CITY OF ALBUQUERQUE

RE: Family Dollar
1400 Gibson Blvd SE
Grading Plan
Engineers Stamp Date: 4/25/18 (L15D049)

Based on the information provided in your submittal received on 5/4/18, the grading plan cannot be approved for building permit until the following are addressed:

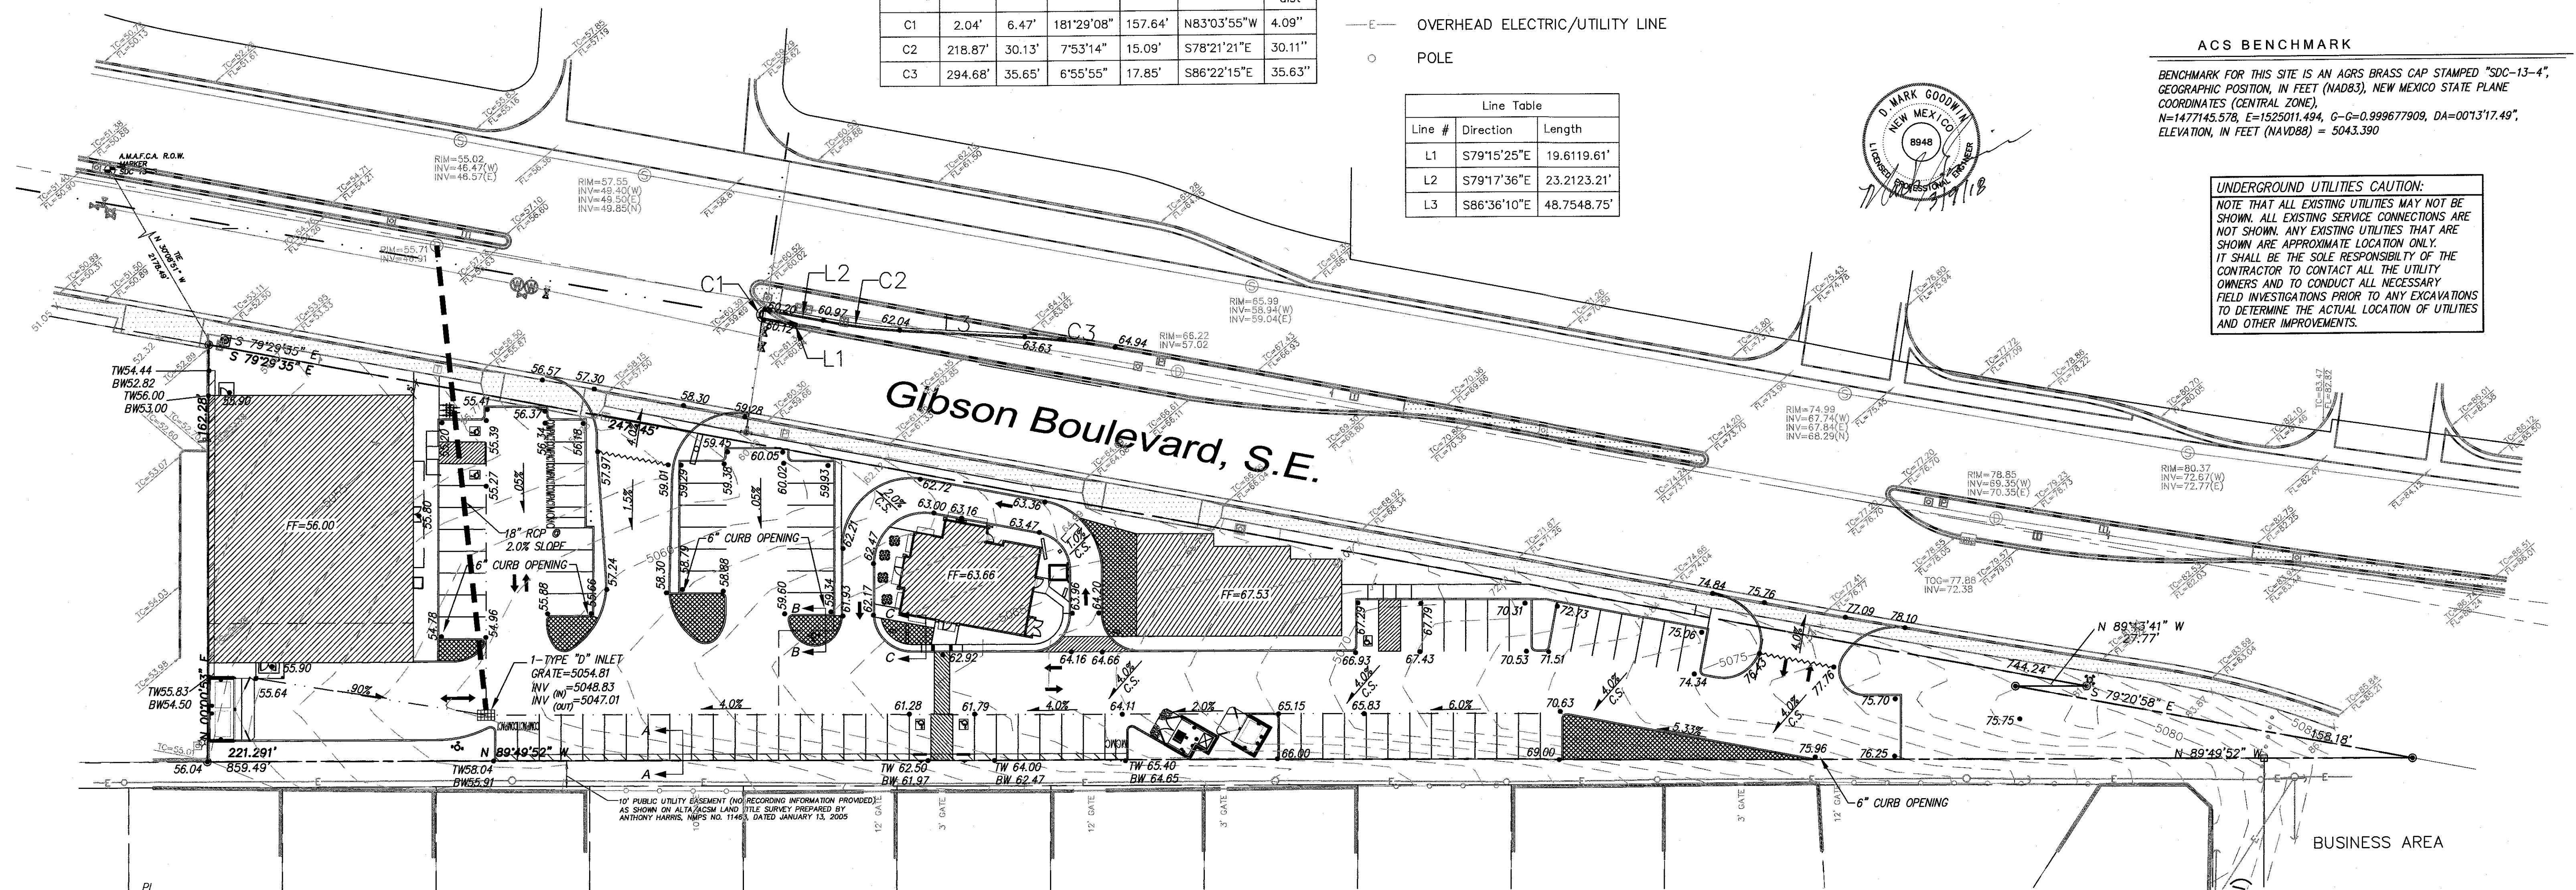
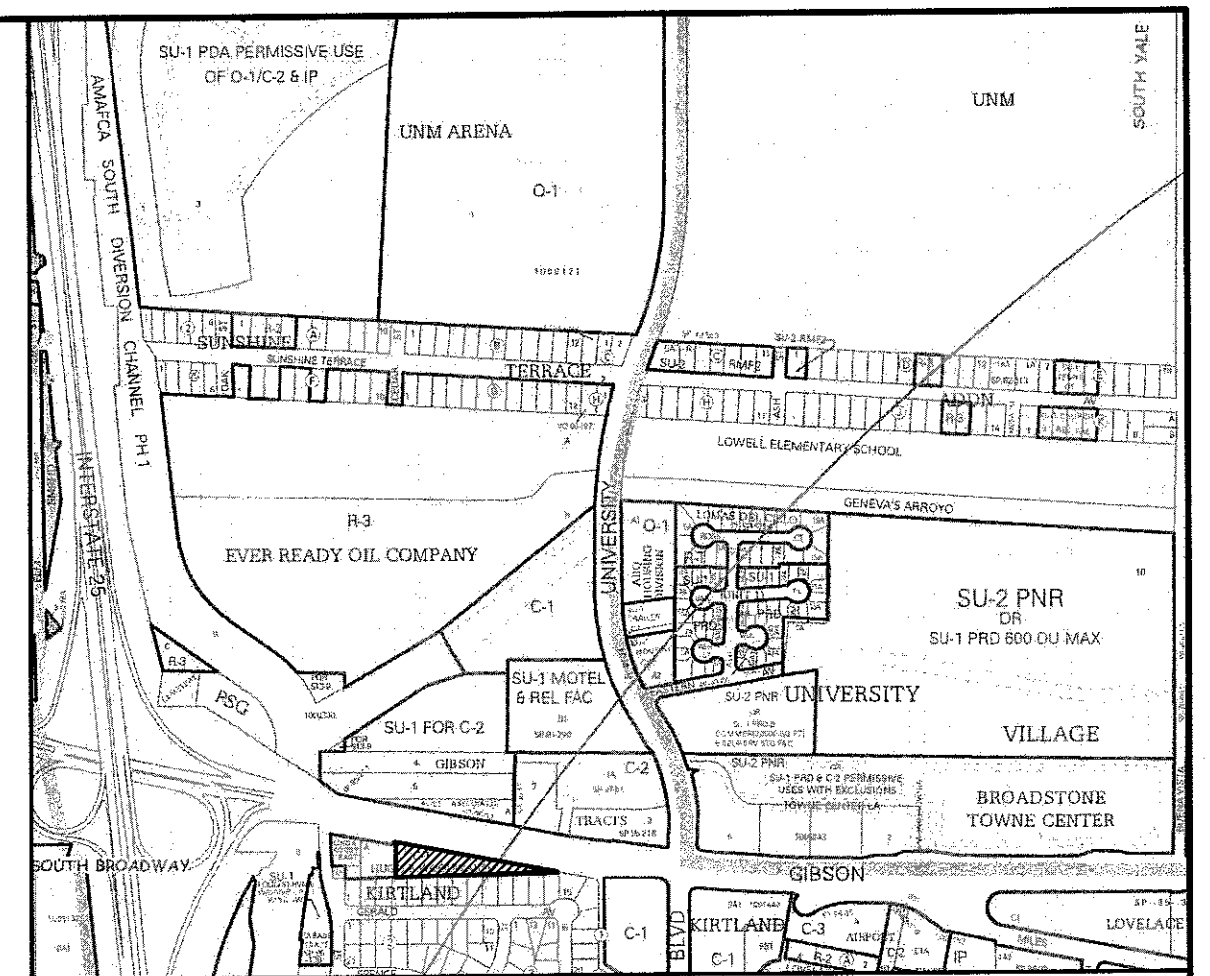
1. The backflow preventer will need to be designed; just providing the manual is insufficient. How will it be maintained? Is it in a manhole or inlet? Provide a detail. How are you attaching a flange fitting to RCP? This will have to be a privately owned and maintained facility and cannot be pushed to DRC or be placed in the public ROW. A Private Drainage Covenant (no Public Easement) will need to accompany it and must be submitted to with the original notarized form, exhibit A (legible on 8.5x11 paper), and recording fee (\$25, payable to City of Albuquerque).

2. Clarification and additional detail is needed on the emergency spillway:
 - a. Increase the density of spot elevations and include top of curb/flowline elevations in the vicinity of the Family Dollar, correct the grade line from 0.05% to 0.5%, and provide the spillway elevation.

- f. Build notes are needed for the channel as well (concrete type, thickness, reinforcement, etc.).
 - g. Include sidewalk culverts with capacity to pass 6.76cfs; these will be built by WO, but should at least be sized and shown on the grading plan.
3. A Private Facility Drainage Covenant is required for the stormwater quality ponds. The original notarized form, exhibit A (legible on 8.5x11 paper), and recording fee (\$25, payable to City of Albuquerque) must be turned into DRC (4th, Plaza del Sol) for routing. Please contact Charlotte LaBadie (clabadie@cabq.gov, 924-3996) or Madeline Carruthers (mtafoya@cabq.gov, 924-3997) regarding the routing and recording process for covenants.
 4. Payment of the Fee in Lieu (Amount = 883CF x \$8/CF, per grading plan, stamped 3/28/18) for the required first flush volume must be made.
